Planning Application Representation:  
Deadline 6 Representation from Biofuelwatch

Proposed Development:  
Drax Bioenergy with Carbon Capture and Storage Project

Proposed Location:  
Drax Power Station, North Yorkshire

Examining Authority Ref:  
EN010120

Drawing file: published-documents / EN010120-000178-6.2.6.8 Drax BECCS ES Vol 2 Figure 6.8 Annual Mean Nitrosamines Maximum Contribution (Baseline).pdf

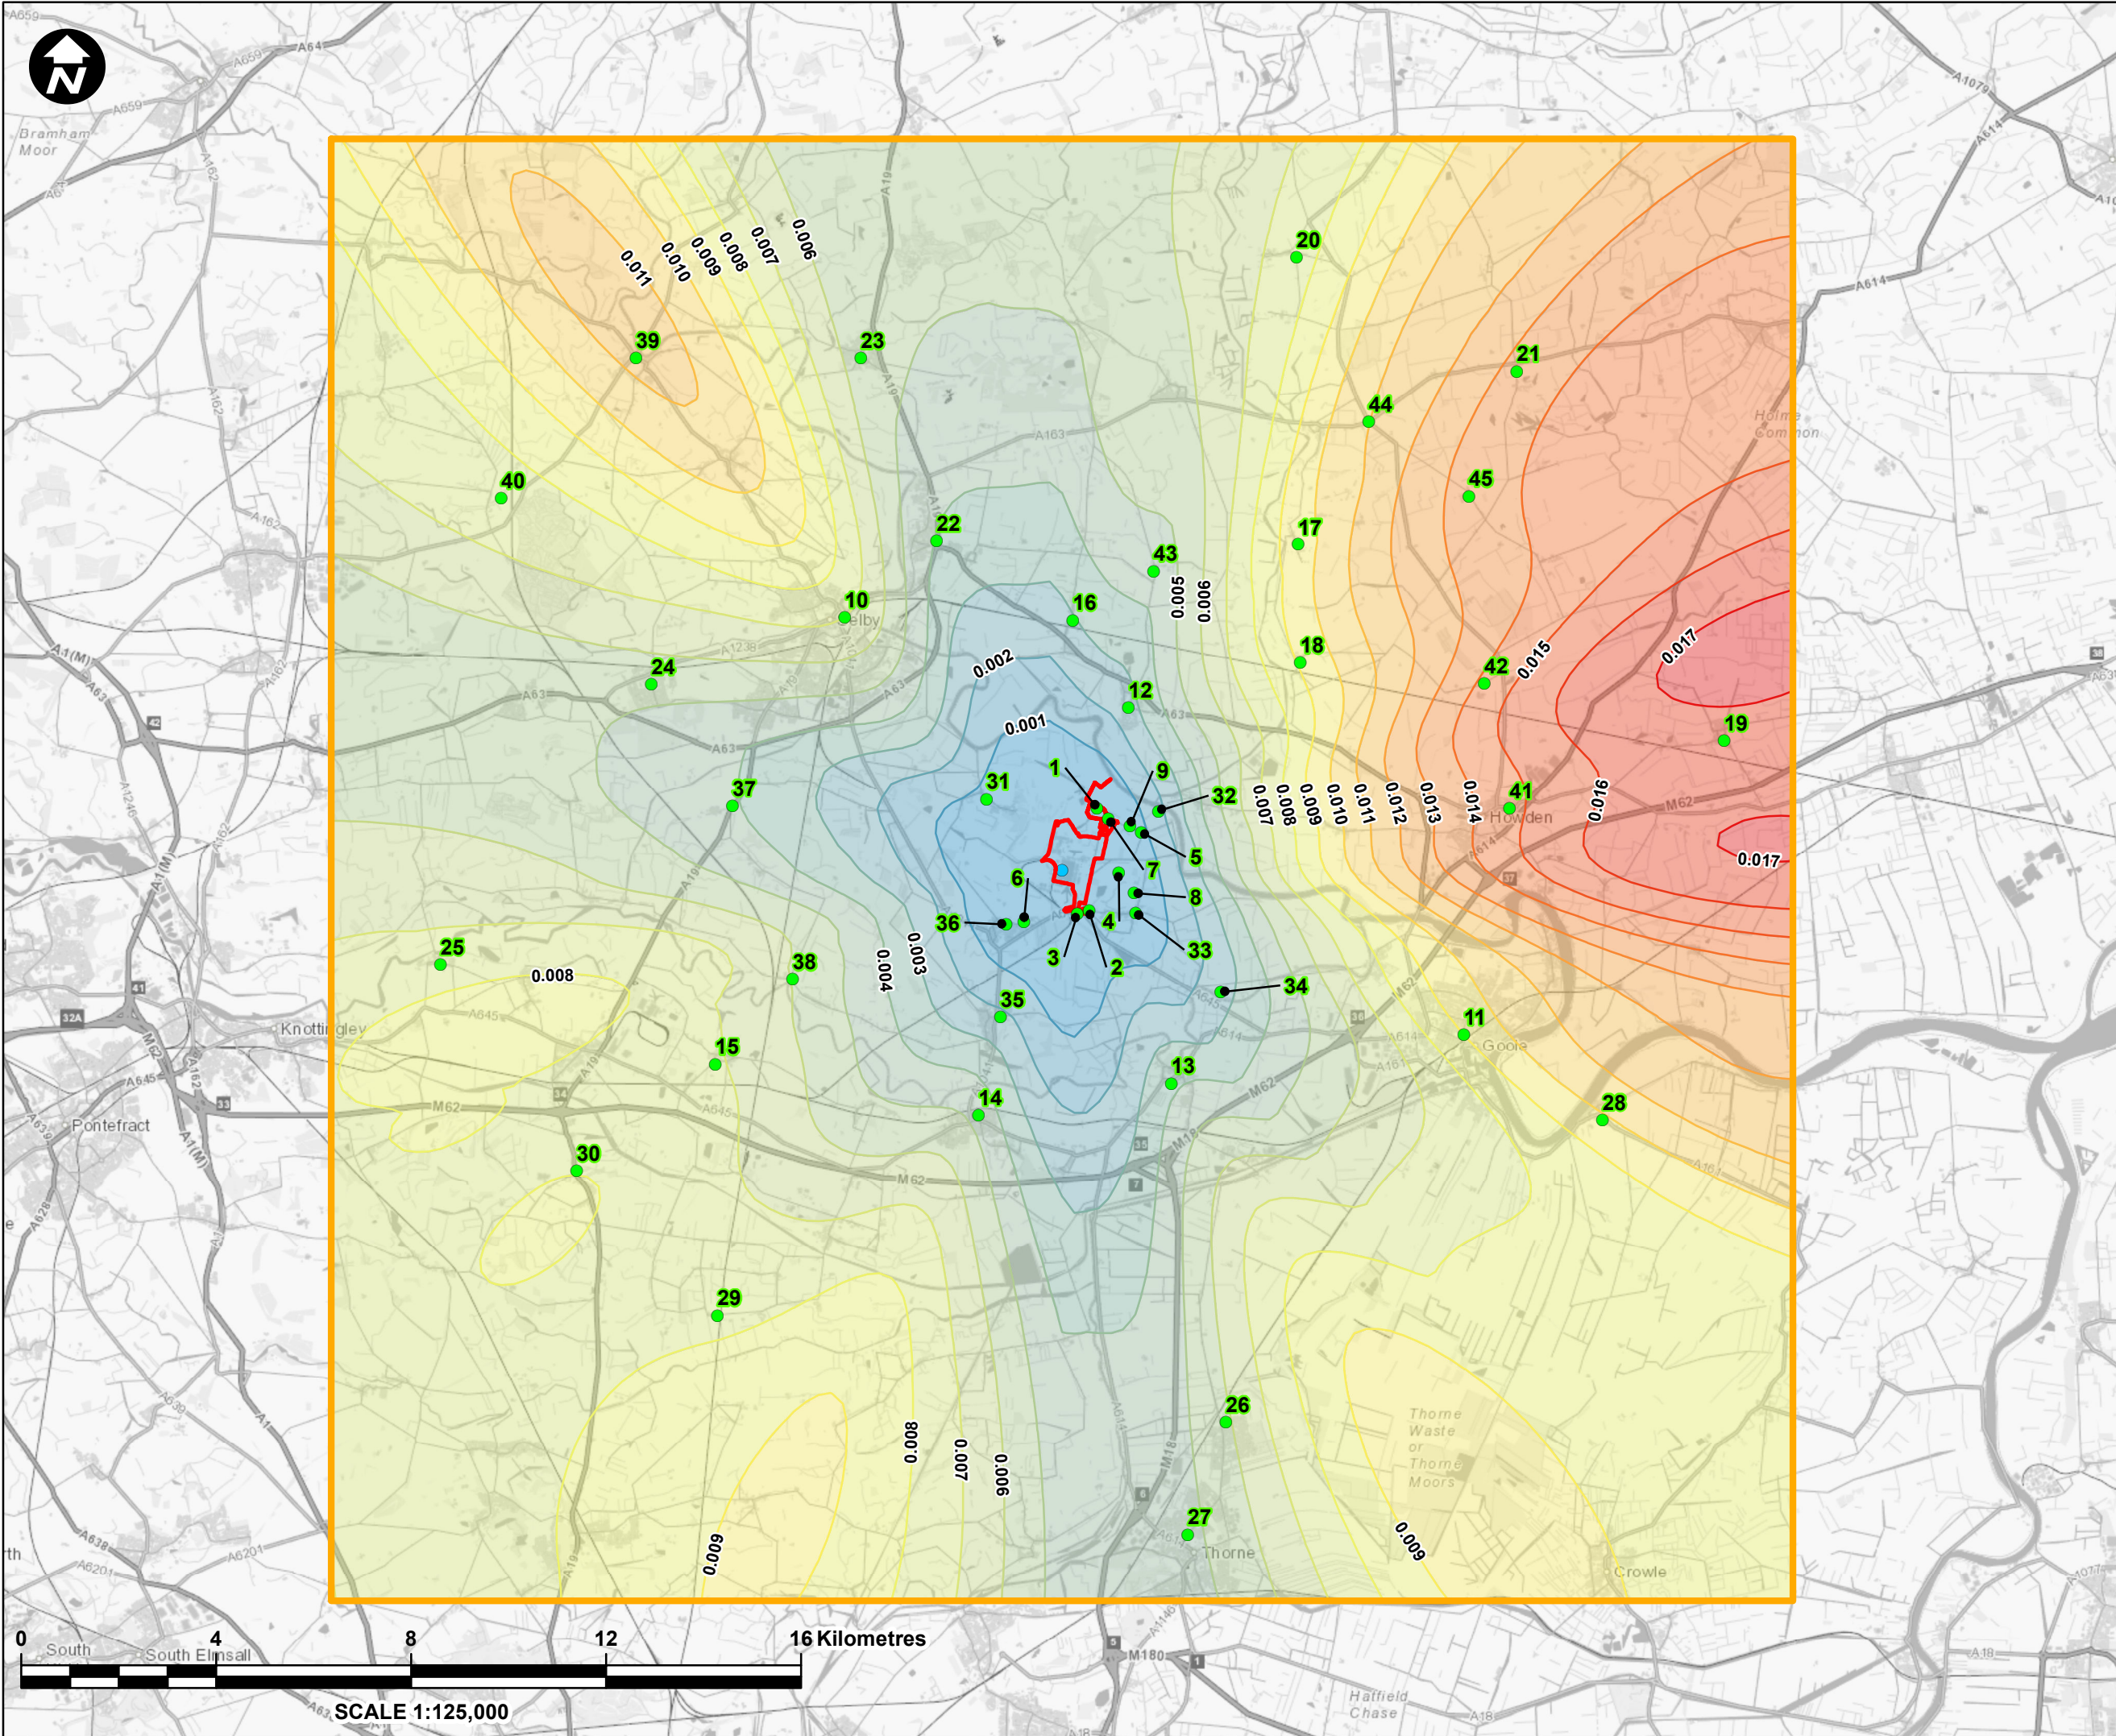
<b>[REP2-073] Paragraph</b>	<b>[REP4-020] Reference</b>	<b>Biofuelwatch’s Comments on Applicant’s Response</b>
57	9.8 (57 – 58)	<p>The applicant’s response, which refers to EA Guidance, does not address the concern that the location with the largest nitrosamine concentrations may not even be on figure 6.8 [APP-075]. Biofuelwatch notes that the Environment Agency was unable to confirm whether the applicant’s approach is correct in their response to the ExA’s questions (AQ.1.4 of [REP2-076]). The applicant’s response says photolytic degradation of the nitrosamines has not been taken into account in the amine chemistry modelling, which will lead to overestimation of pollutant concentrations at distance from the stack. Any such overestimation may, however, not be significant at this geographical scale because of the stability of nitrosamines in the atmosphere (see paragraph 72 of Biofuelwatch’s deadline 2 submission [REP2-073]) and because photolytic degradation requires sunlight (and therefore will not occur at night and will be greatly reduced when the sun is obscured by clouds). Biofuelwatch also notes the applicant did not comment on the findings of the Norwegian Institute for Air Research and the Norwegian Institute for Water Research (in collaboration with the Norwegian Institute of Health and others) that reported significant nitrosamine concentrations over considerable distances (considered in paragraph 68 of Biofuelwatch’s deadline 2 submission).</p> <p>Biofuelwatch requests that the ExA requires the applicant to carry out modelling that shows, beyond doubt,</p>

<b>[REP2-073] Paragraph</b>	<b>[REP4-020] Reference</b>	<b>Biofuelwatch's Comments on Applicant's Response</b>
		<p>the location with the predicted highest nitrosamine concentration together with one or more supporting diagrams to show the full extent of the geographical spread of nitrosamine concentrations. Biofuelwatch also requests diagrams showing the cumulative modelled nitrosamine impact with other consented plants to aid the assessment of cumulative impacts.</p>
59	9.9 (59 – 74)	<p>The modelling assumes both no existing amine/nitrosamine emissions and no background amines/nitrosamines. Biofuelwatch is not aware of any existing monitoring equipment, but existing emissions levels and environmental levels must be measured and included in the assessment. The applicant's response acknowledges the possibility of amine emissions from biomass combustion and goes on "Drax's current permit to operate makes no reference to any requirement to either control or monitor emissions of amines". This is then followed by the incorrect conclusion that "it is logical to conclude that the impacts of amines from the biomass combustion are not of environmental concern". This is flawed:</p> <ul style="list-style-type: none"> <li>• because amines clearly are of environmental concern (as shown by the applicant's proposal and the EALs defined by the EA)</li> <li>• because the proposal will increase amines and nitrosamines</li> <li>• because it assumes that all matters of environmental concern are regulated by permit to prevent environmental impacts. This is clearly not the case with impacts of non-threshold pollutants are inevitable regardless of whether they are measured and regulated.</li> </ul> <p>Without an assessment of existing emissions, the cumulative impact of the proposal cannot be properly assessed. It should be noted that the applicant has included existing emissions of other pollutants in its assessment, so it is Biofuelwatch's position that it must do so for amines and nitrosamines.</p>

Plate 1.2 - Modelled Buildings Layout

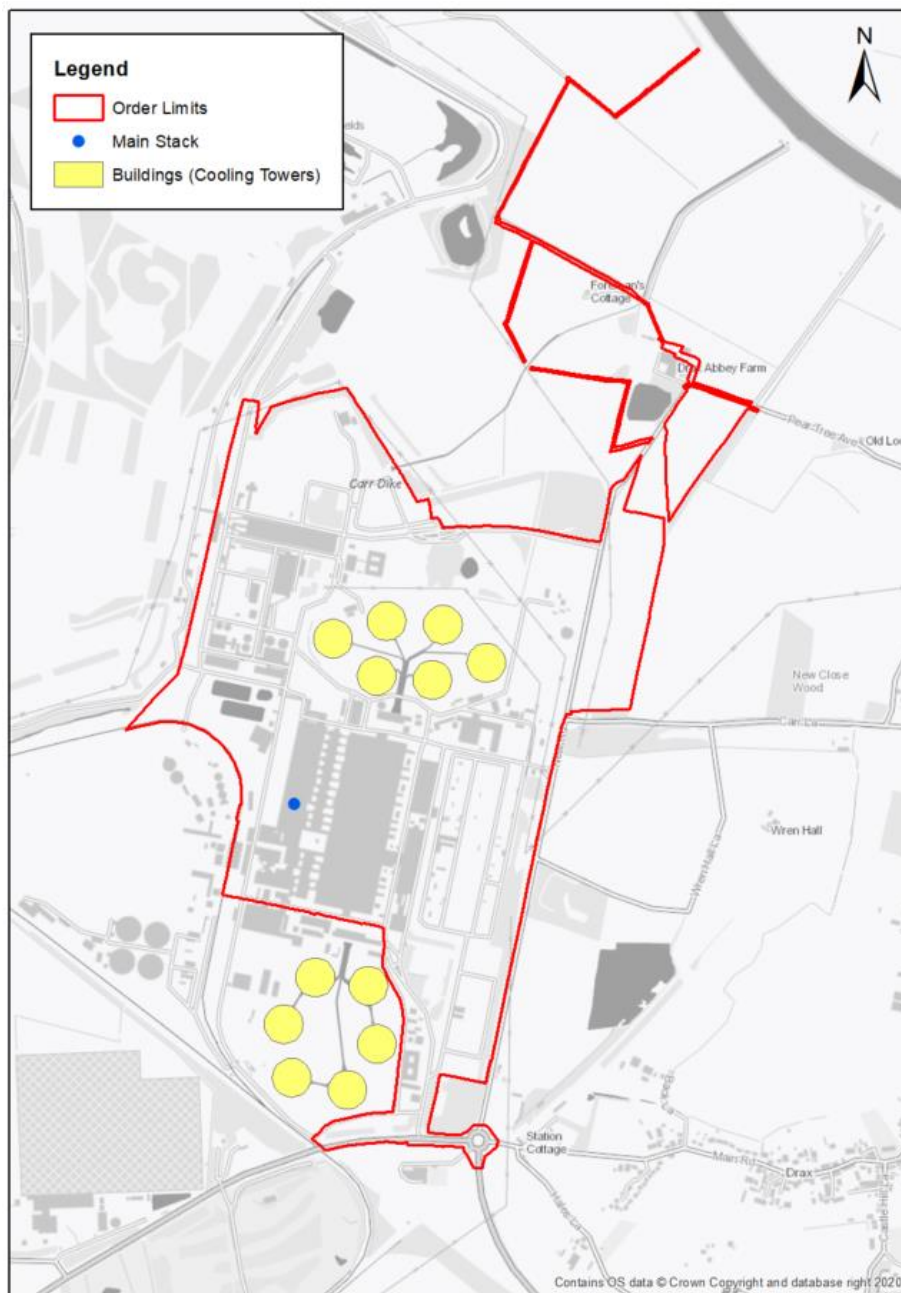
<b>[REP2-073] Paragraph</b>	<b>[REP4-020] Reference</b>	<b>Biofuelwatch's Comments on Applicant's Response</b>
102	9.11 (85 – 106)	<p>The applicant's response says "Biofuelwatch note that the EfW at Kirk Sandall has been modelled without buildings. This is correct but this has no significant impact on the conclusions of the assessment. The primary impact of buildings on dispersion is to rapidly mix pollutants from lofted plumes down to ground level due to enhanced turbulence in the wake of the building. However, once a plume has become well mixed with the atmospheric boundary layer, as happens with distance downwind from a source, the impact of any enhanced mixing near the source is much reduced. Kirk Sandall EfW lies 20km south-south-west of the Drax power station and where there is potential for cumulative impacts between the Proposed Scheme and Kirk Sandall, the influence of near source building effects will, therefore, be negligible."</p> <p>However, the applicant's own figures show peak nitrosamine impacts occur at distances at or in excess of 15km with impacts extending an unknown maximum distance. Nitrosamine concentrations arising from Drax's emissions will combine with Kirk Sandall emissions and impact nitrosamine concentrations near Kirk Sandall. There is therefore the potential for significant underprediction of environmental nitrosamine concentrations near Kirk Sandall since buildings near Kirk Sandall have not been modelled.</p>
